Land off Lees Hall Road, Dewsbury and Land off Ravensthorpe Road, Dewsbury

2016/94117 and 2016/94118 - Outline application for residential development

Highways Development Management (HDM)'s comments on the above application are as follows:

Cumulative Impact Assessment with regards to 2016/94117 and 2016/94118

Land off Lees Hall Road & Ravensthorpe Road,
Dewsbury
Base + Committed + Cumulative Development

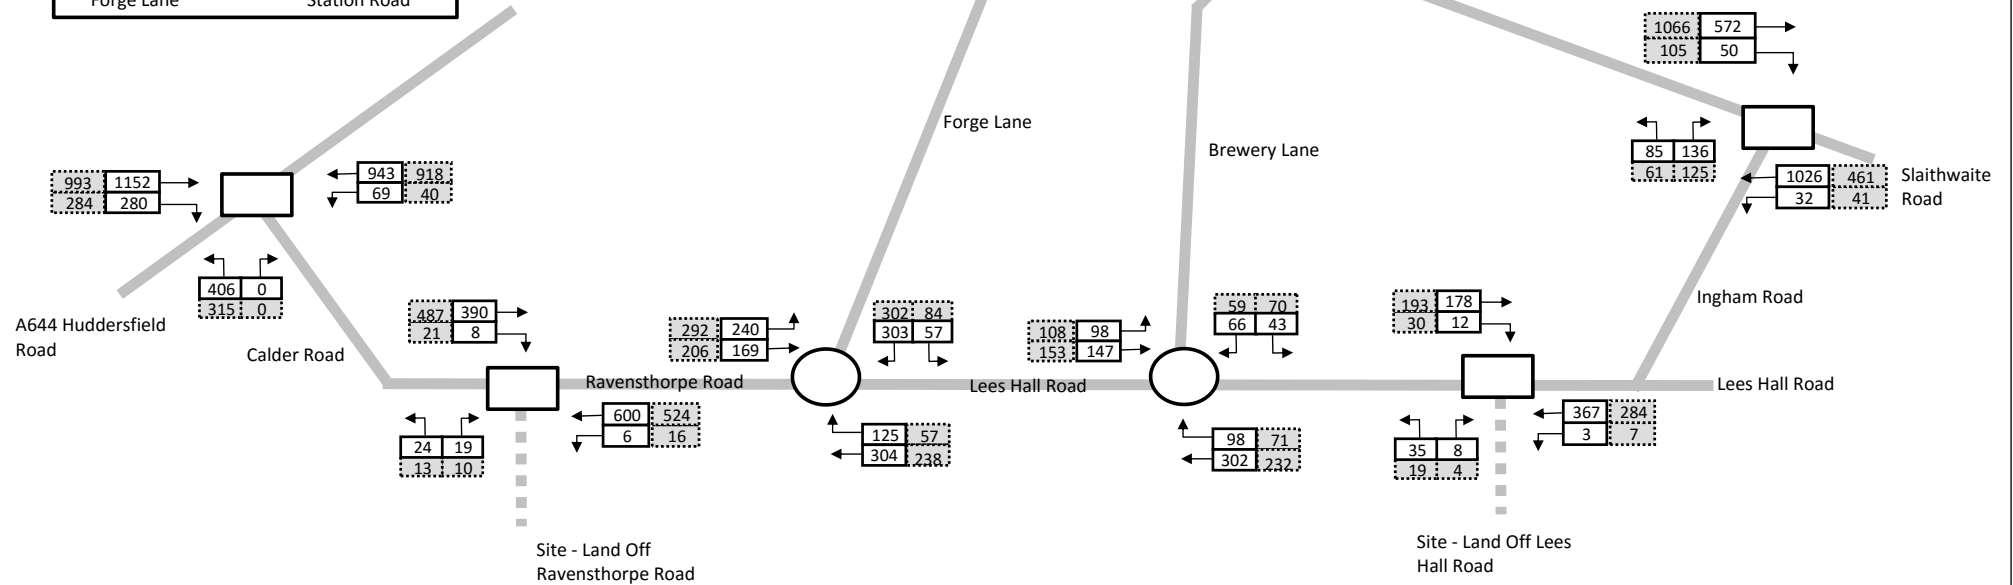
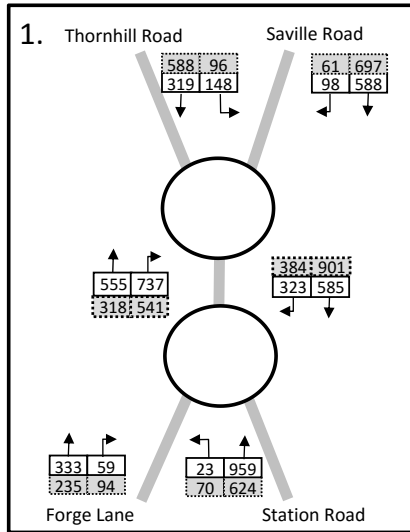
2016 and 2021 Base + Committed + Development flows have been combined with the above to create 2016 Cumulative Development Flows and 2021 Cumulative Development Flows.

The results of the materiality assessment demonstrate that all junctions within the study area, with the exception of the Ingham Road/Slaithwaite Road junction will experience a material increase in the 2016 assessment year and as such have all be subject to operational assessment as per the models presented within the submitted Transport Assessment for both the 2016 assessment year and the 2021 sensitivity assessment year. The results are as follows:
